From: [Karen Hallinan](#)
To: [Jeremiah Cromie](#)
Cc: [Steve Hallinan](#); [Dana Kennedy](#)
Subject: Fwd: Clear View (SE-21-00017) SEPA Questionnaire Response, Parcel #11884
Date: Friday, September 10, 2021 10:47:12 AM

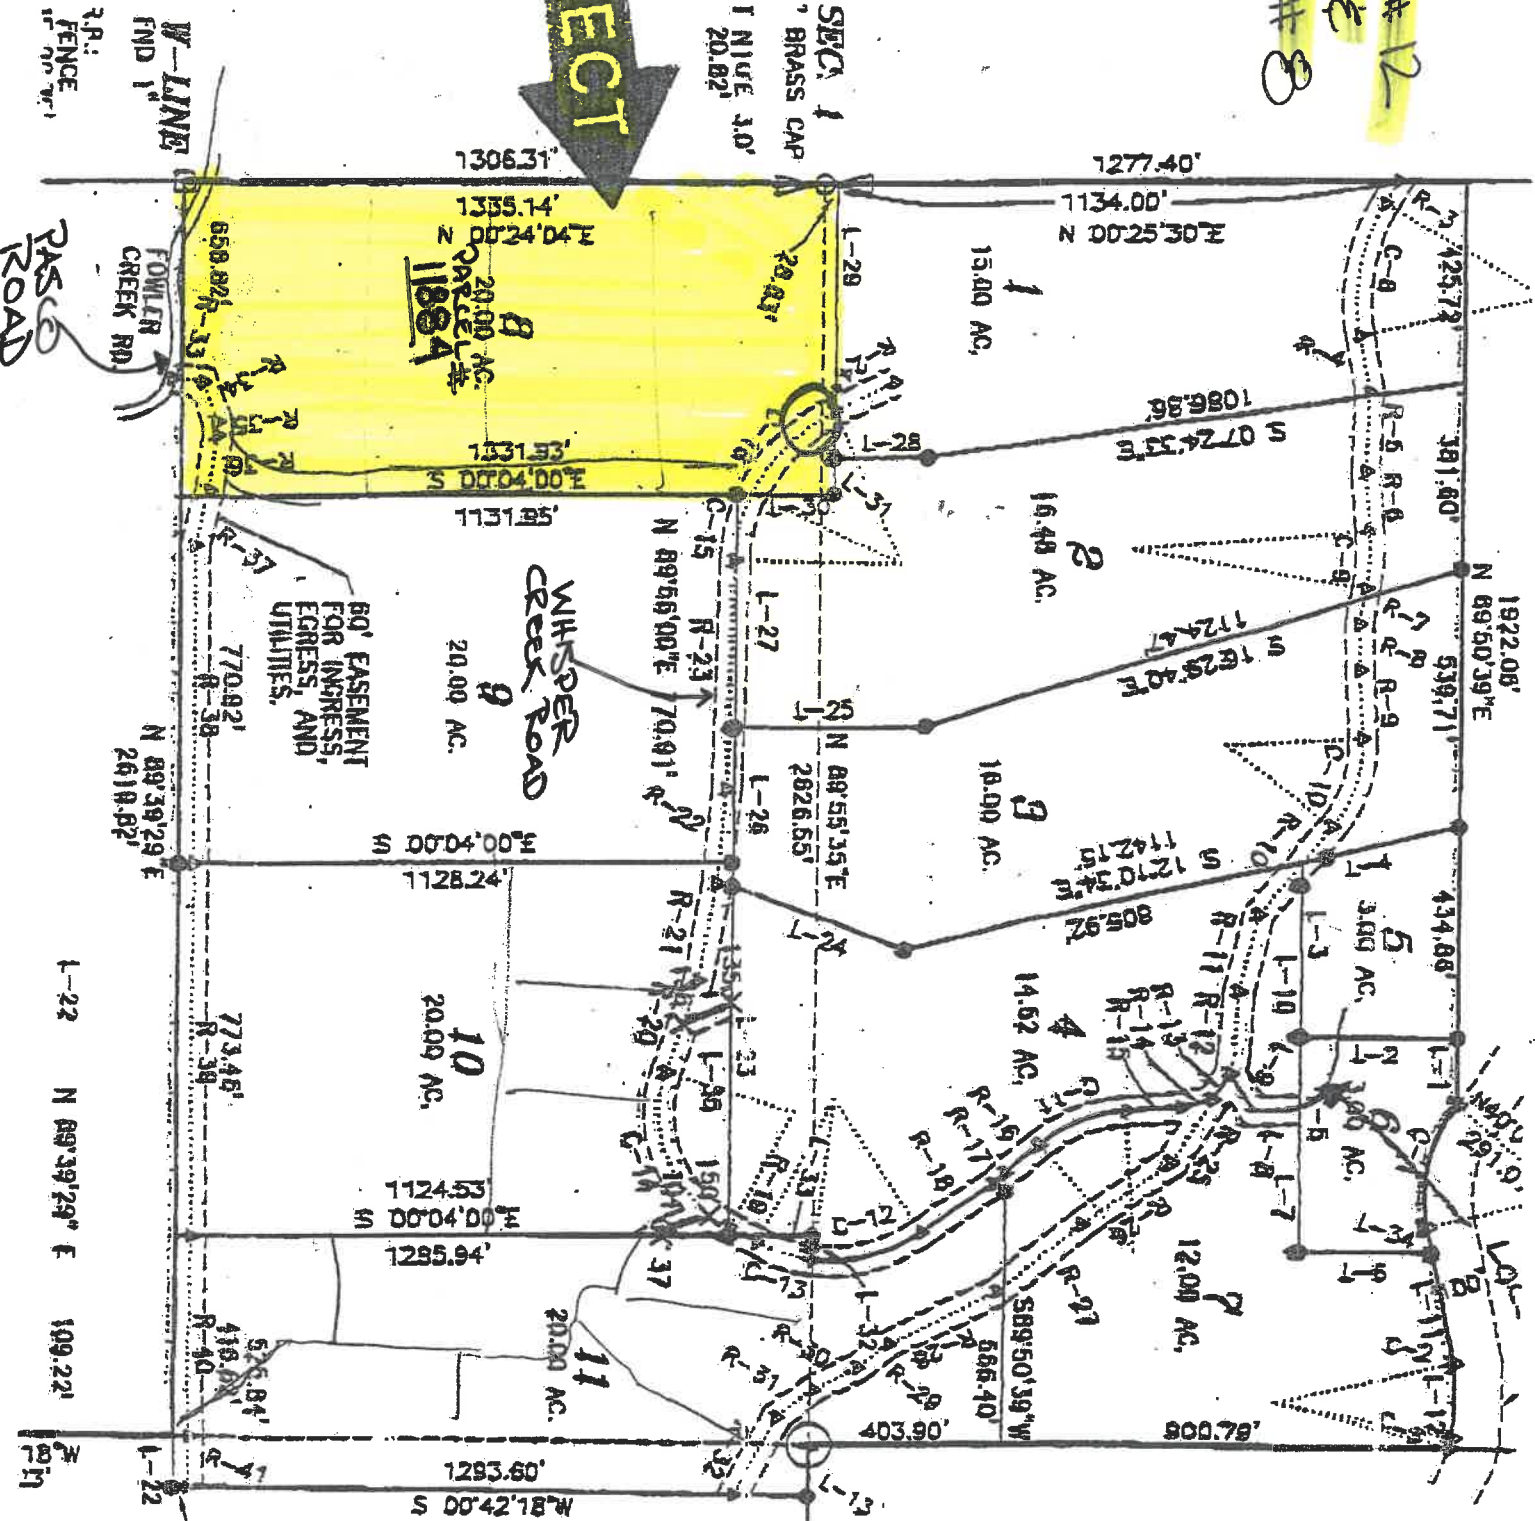
At this point there is no need for a secondary Ingress and Egress access road to our private community of Westside Heights as we are currently at the maximum number of lots for a single Ingress and Egress.

Any second access road within the Westside Heights community is for the sole purpose of property owners and homeowners use only. All roads are private and No public access can be granted. Any access road has to meet all Kittitas County requirements along with all the Westside Heights CC&R requirements. Westside Heights is a gated community, therefore any access road will require to have a security gate.

2c Applicant states that water will be used to reduce dust as needed during and after construction. All roads within Westside Heights are asphalt surfaced, therefore any new road will be required to be surfaced with asphalt.

3a, 3b 1-3. Applicant states there will be No surface water issues. What will happen to rain/snow water on an asphalt road? We are concerned of future damage of current HOA road which is maintained by the HOA members.

8L. Applicant wants to include Pasco Road residents to access proposed road. NO public access can be granted - Westside Heights is a private community.
